THE LANDINGS OF DENMARK

FILING NO. 2 - UPDATED PLANS

CONSTRUCTION PLANS

V2_Construction Drawings Redlines.pdf Markup Summary

BYRD COURT

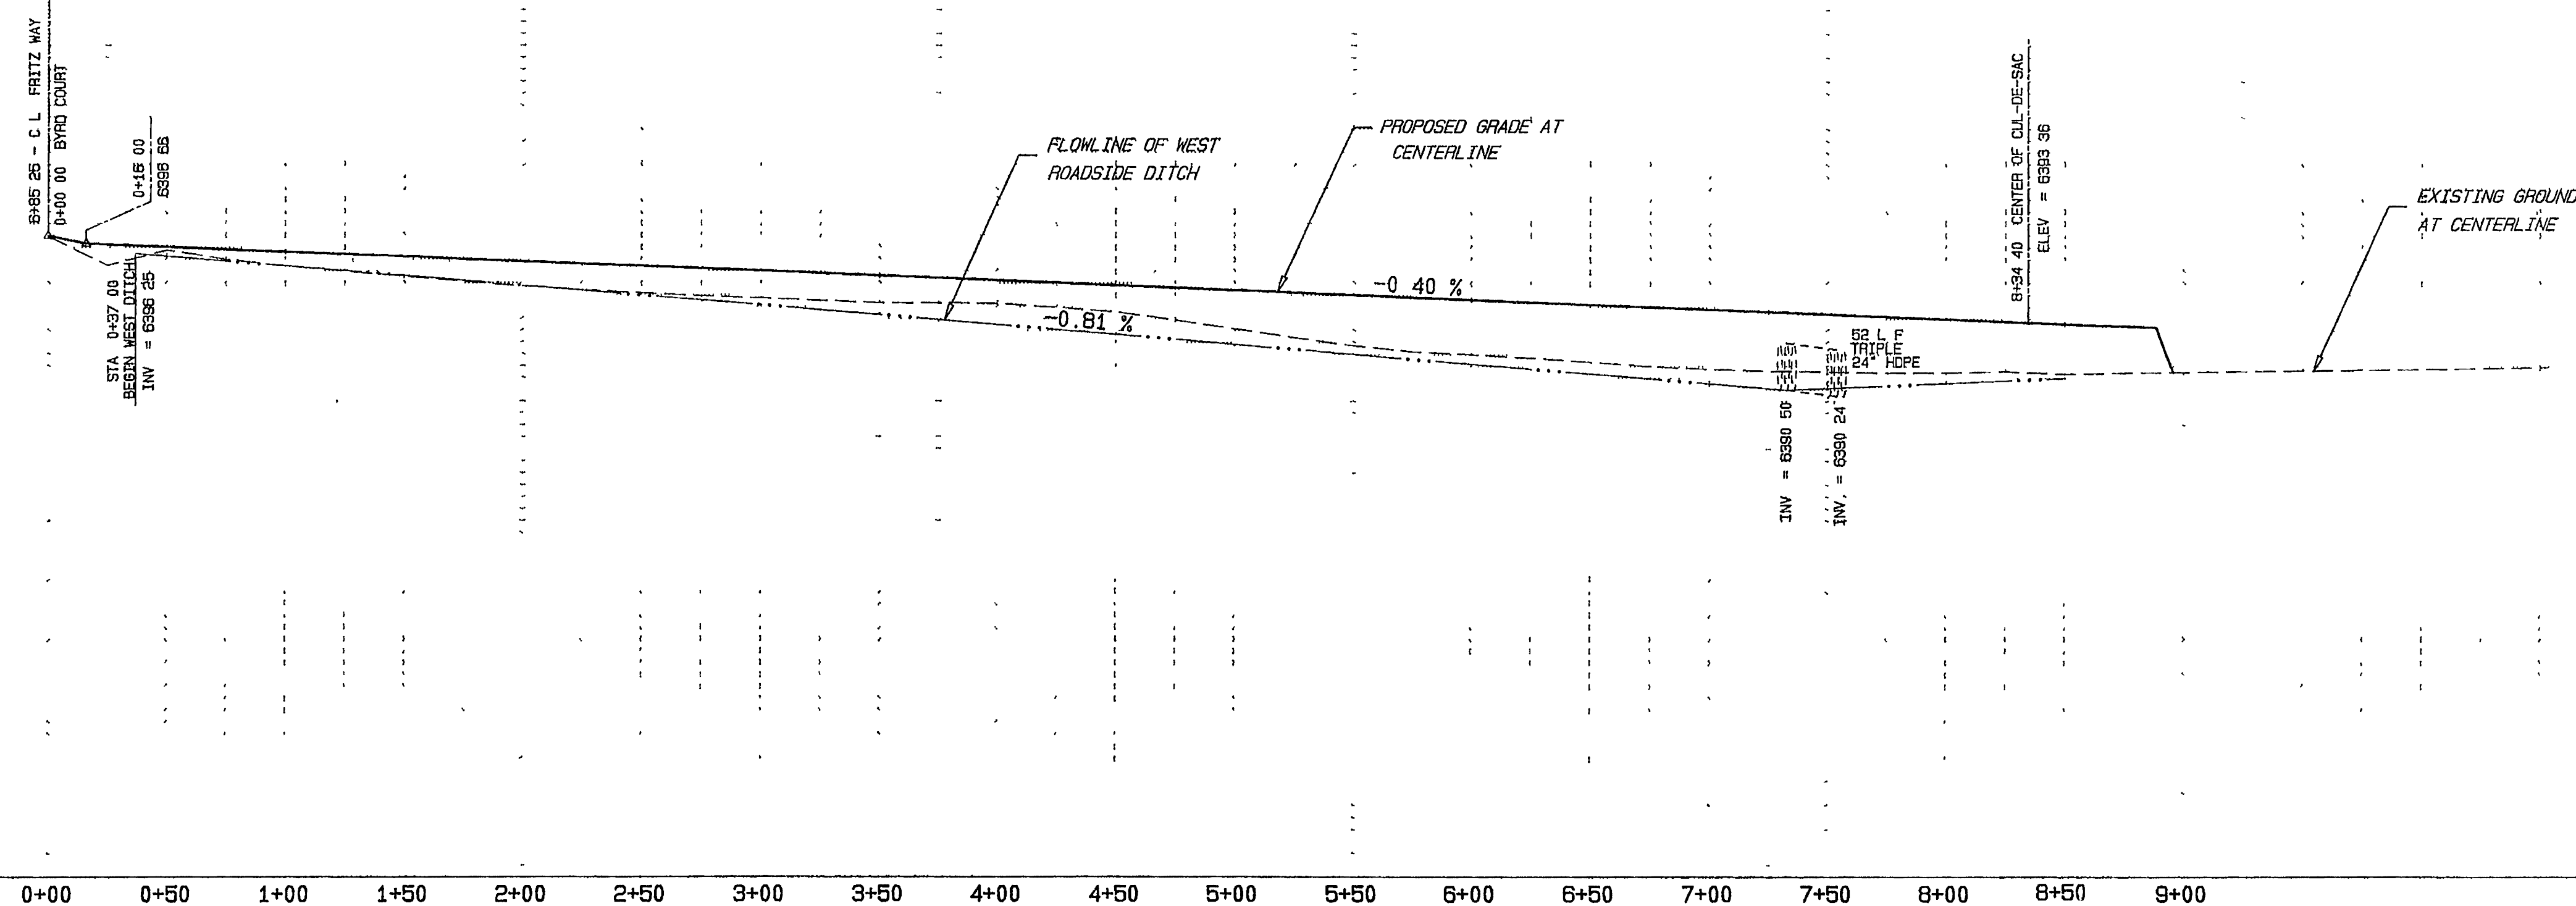
Indicate where ditch
transitions from 10' to 8'
bottom

Unresolved:
Per ECM Table 2-5
Minimum centerline slope
for local rural street is 1.0%.
If grading is not able to be
revised, provide deviation
for centerline slope with
hardships for obtaining
slope in criteria.

ROCK RIPRAP ENERGY DISSIPATOR DETAIL  
NOT TO SCALE

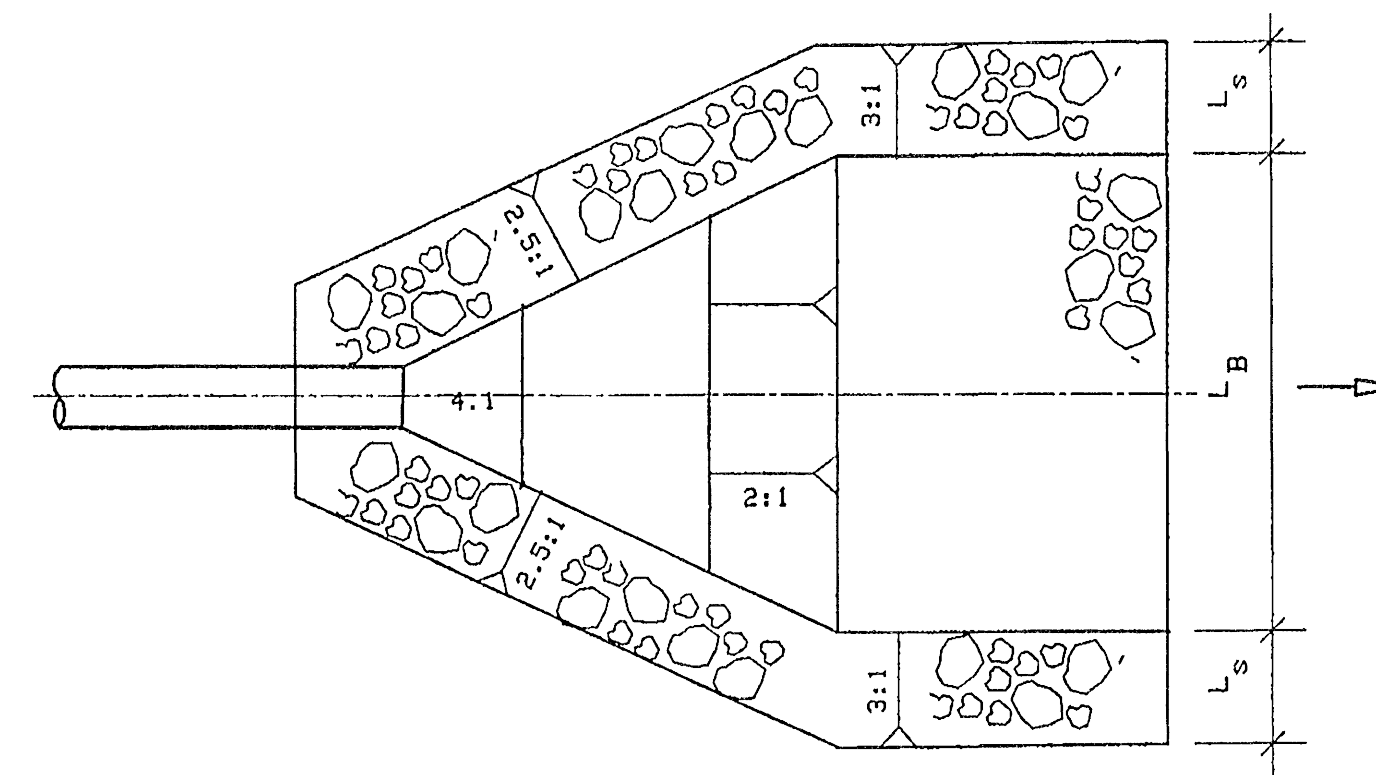
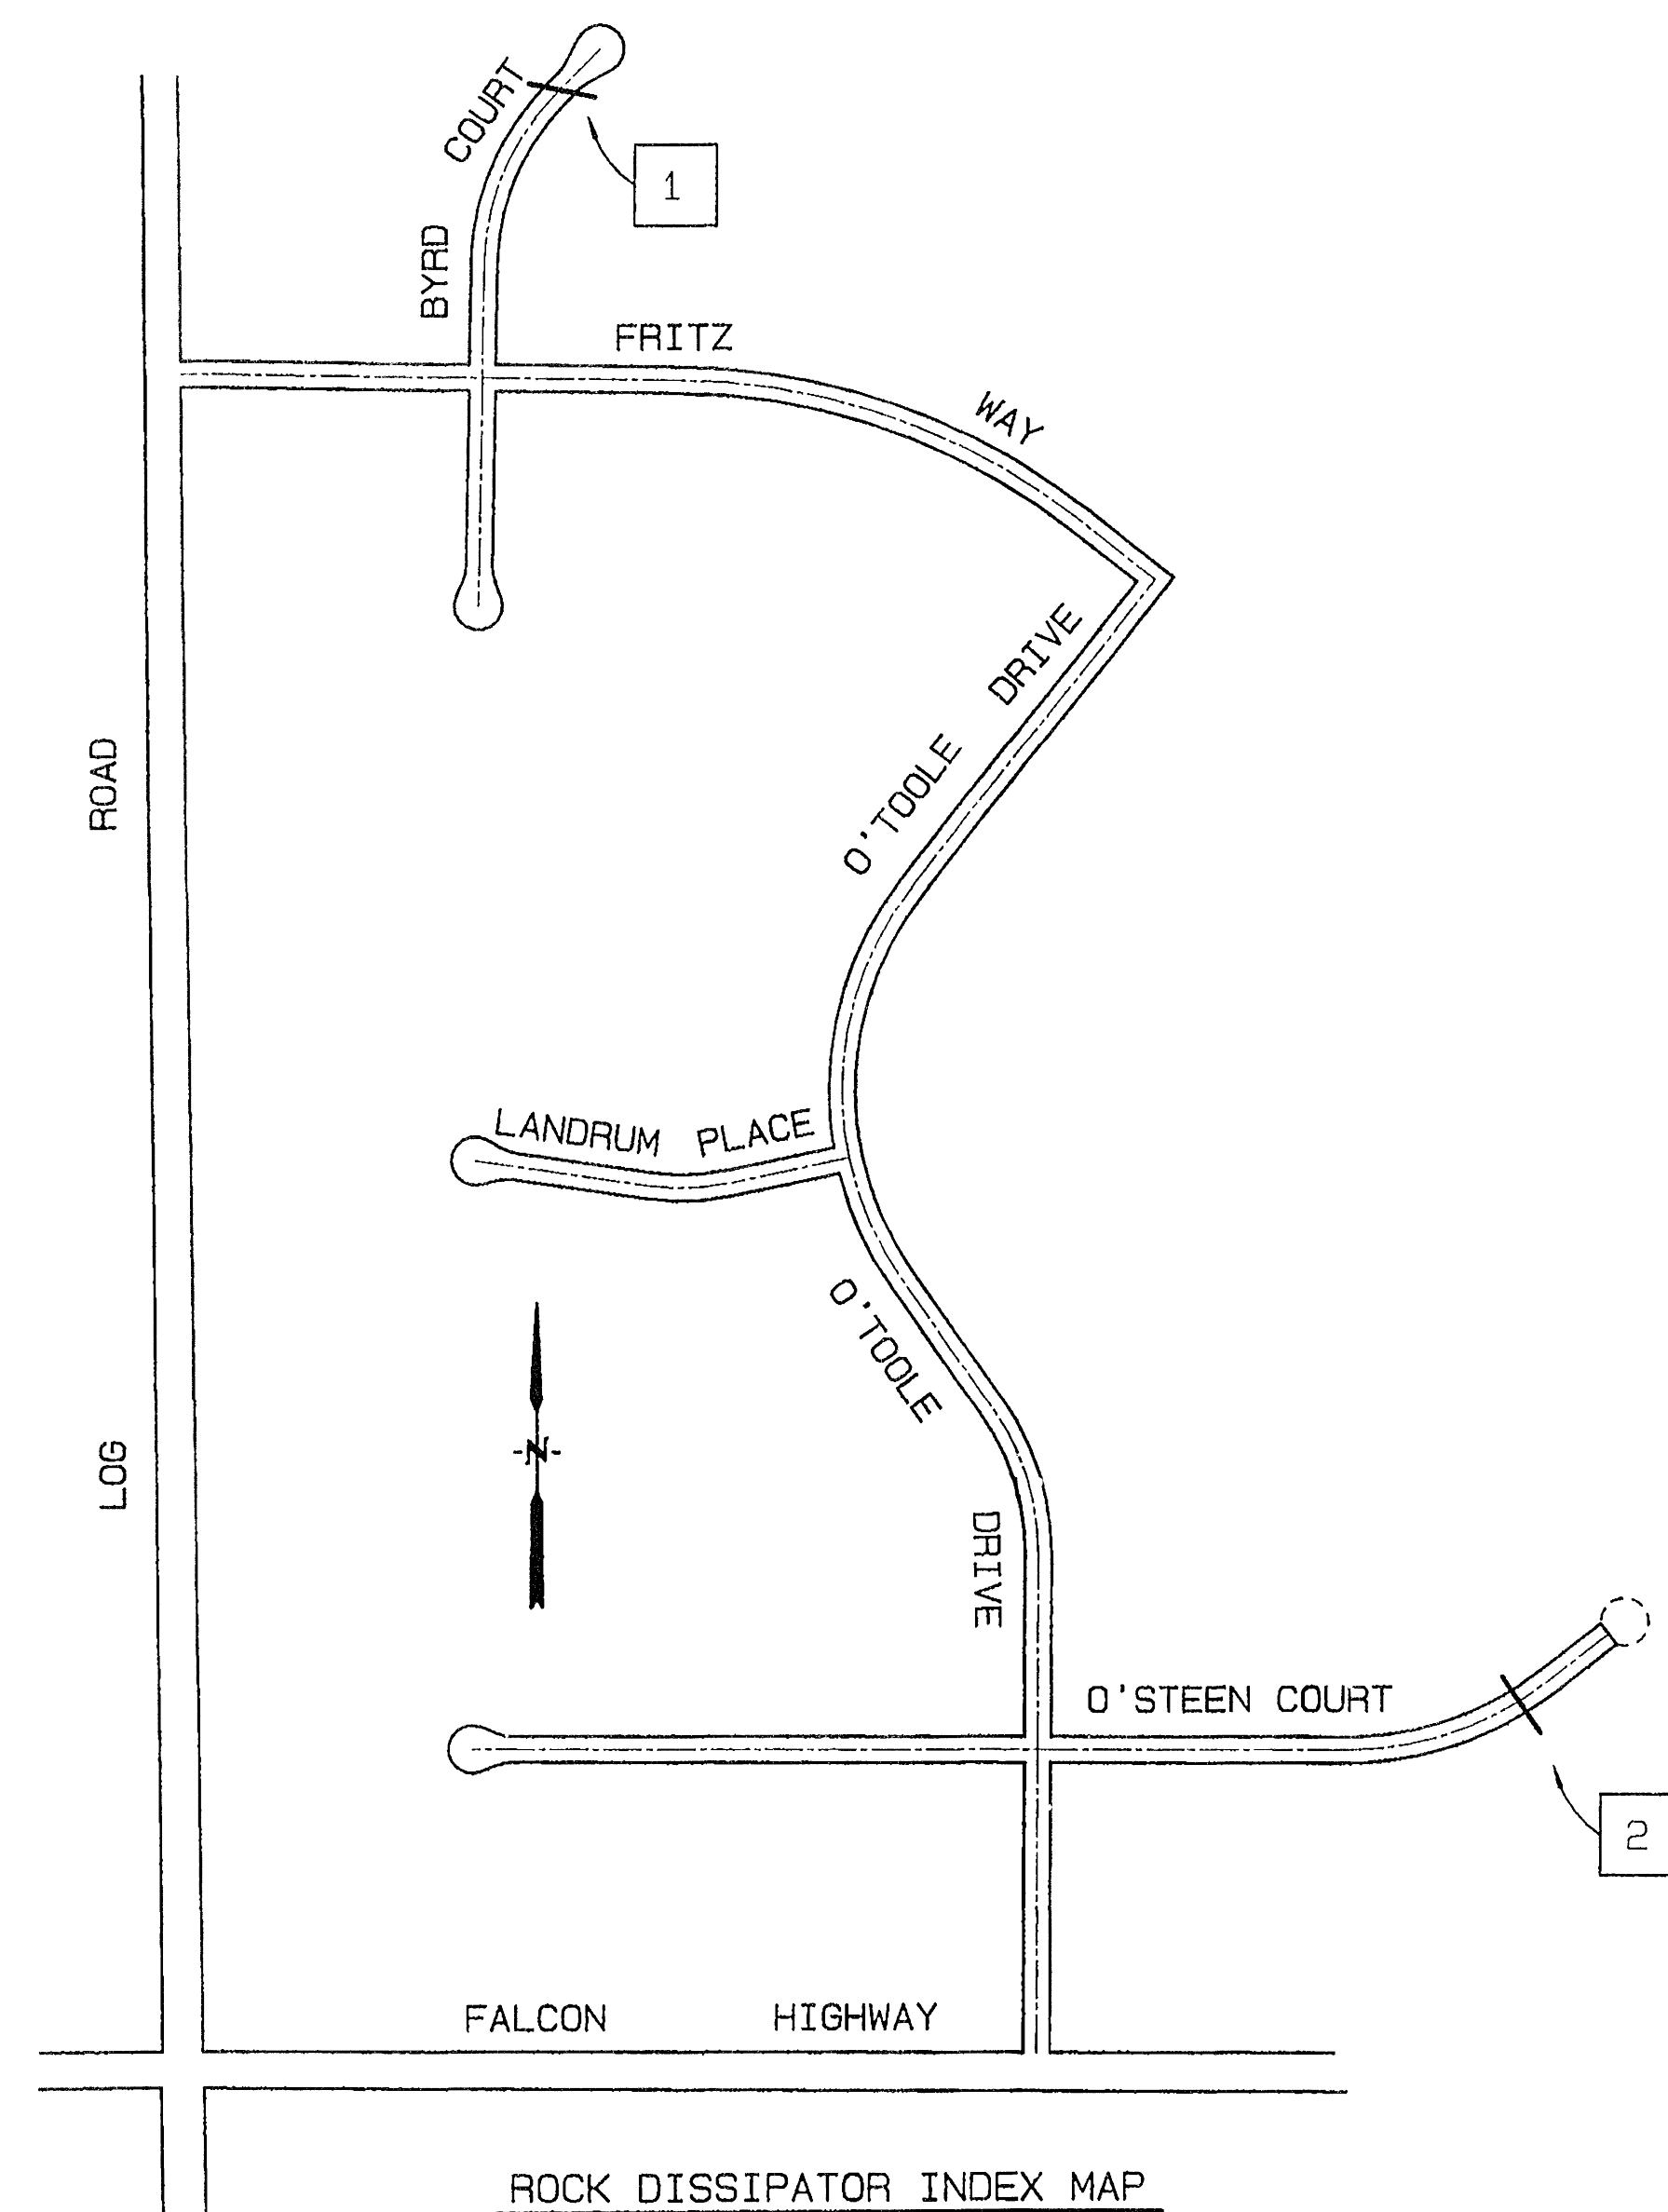
provide calculations in DR
